Date: 19 January 2021

Application Ref.: F/4/20/OUT

Proposal: Outline planning application (with all matters reserved except for access) for the development of up to 1,500 dwellings (Use Class C3), 60-bed care home (Use Class C2), up to 9,000 sqm of employment floorspace (Use Classes B1), local centre of up to 2,350 sqm including up to 900 sqm retail/ commercial (Use Classes A1-A5) and 1,450 sqm community/ leisure floorspace (Use Classes D1-D2), land for a two-form entry primary school (Use Class D1), public open space, allotments, new sports pitches and associated facilities, drainage, parking and associated access, infrastructure, landscape, ancillary and site preparation works, including demolition of existing buildings and part removal of existing runway hardstanding.

Location: Land at Ford Airfield Ford

Figure 4: Typical illustrative plan showing noise mitigation principles, subject to detailed noise assessment and layout planning at reserved matters stage. Not for approval of detailed block layout or type/mix of housing.

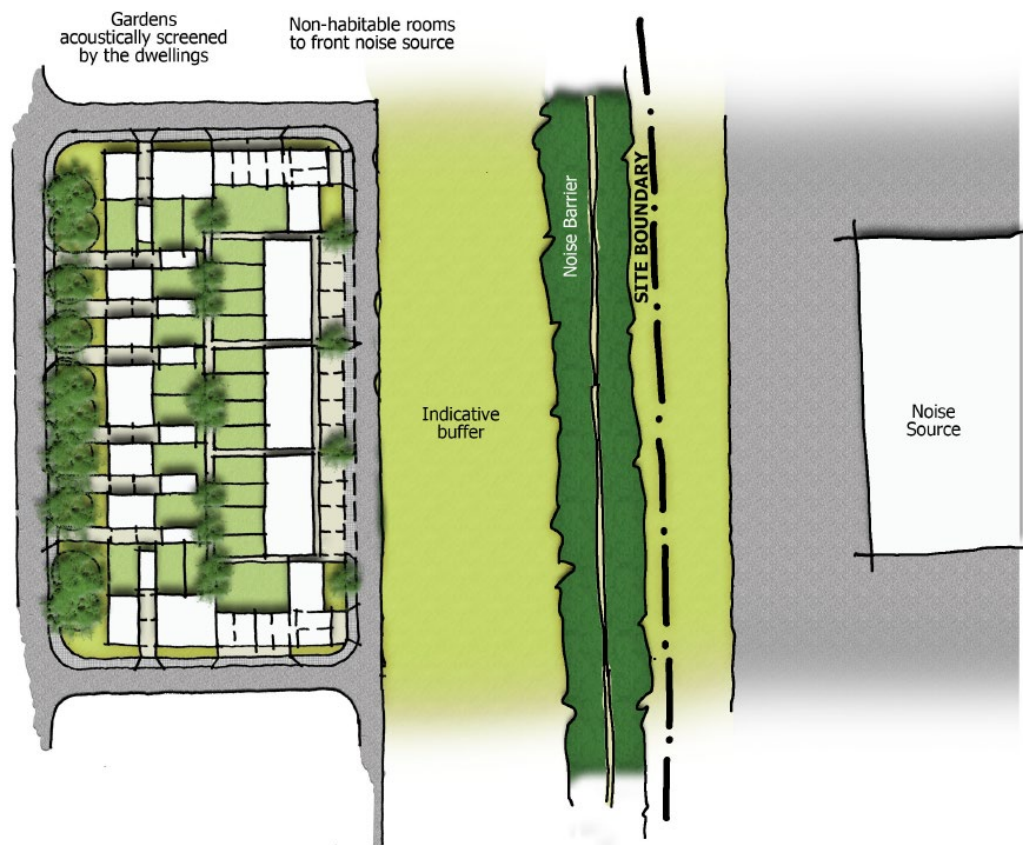
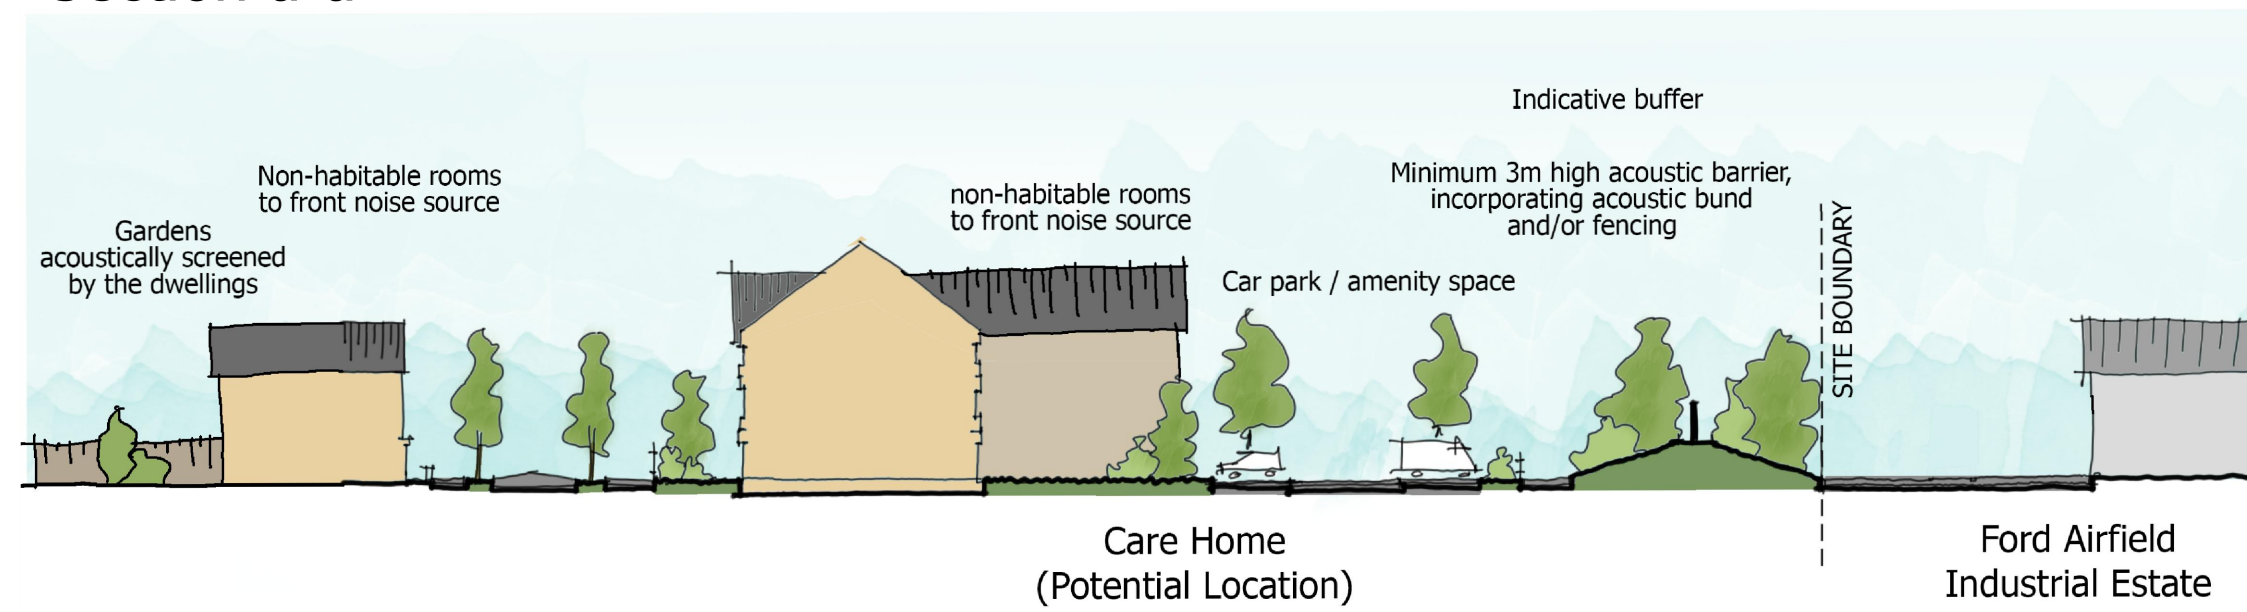
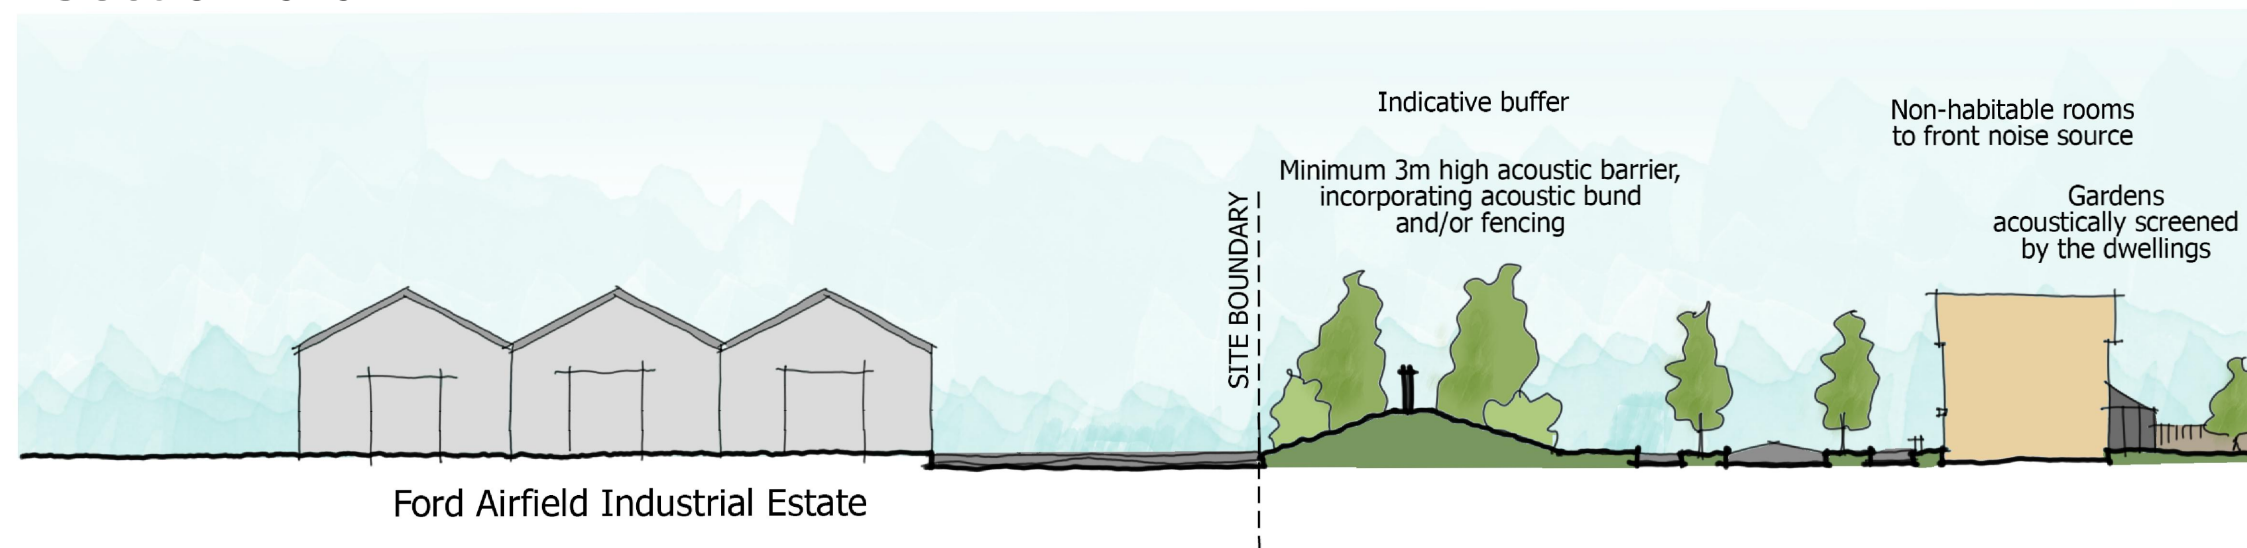
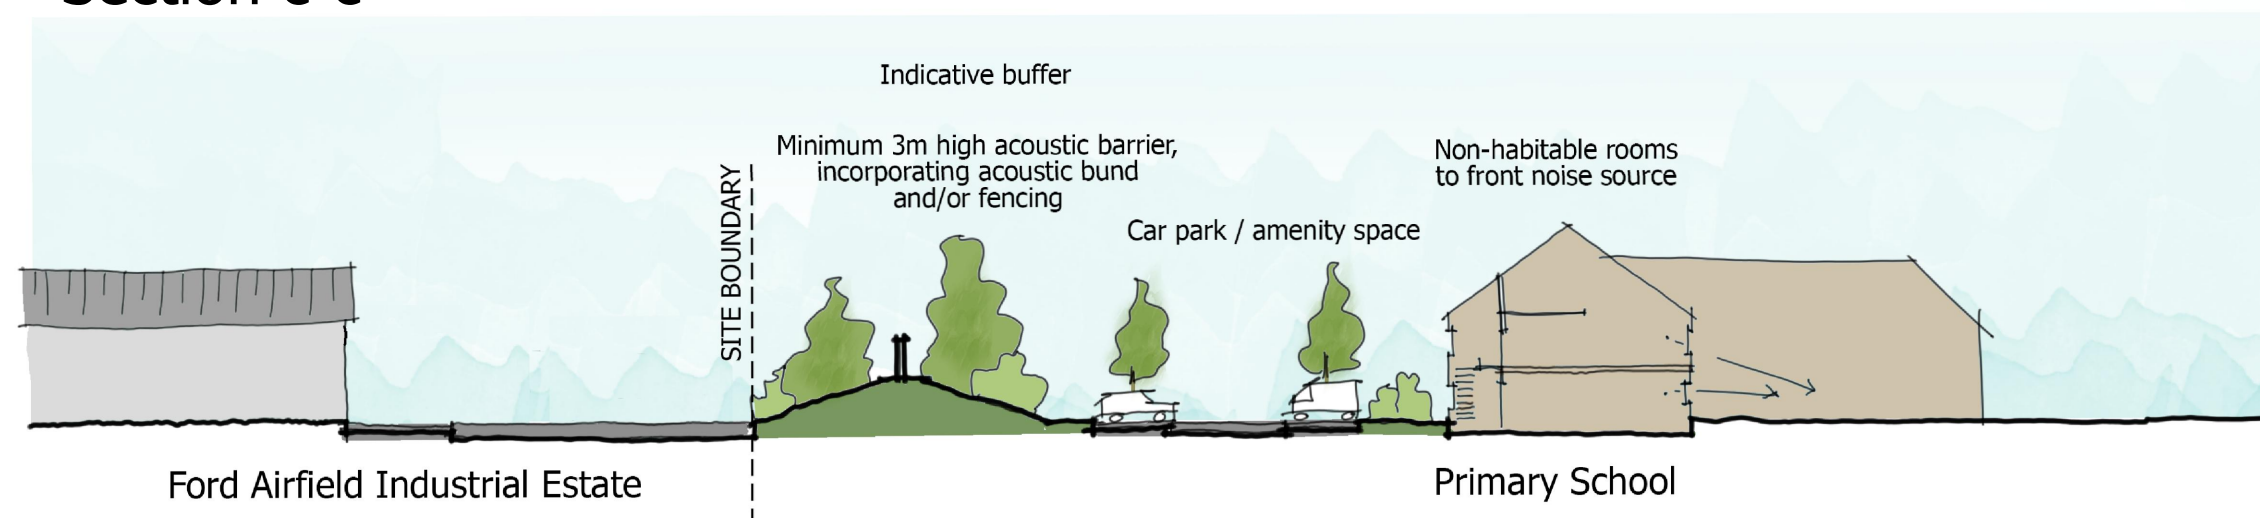
The noise mitigation relied on by the applicants and detailed in the ES Addendum looks completely unrealistic. The mitigation proposed includes:

- Gardens not to face industrial properties
- No habitable rooms of residential properties to face industrial sources

The applicant should be asked to provide more detail on how the residential properties can be configured to ensure no habitable rooms face any of the industrial sources in the vicinity of the site.
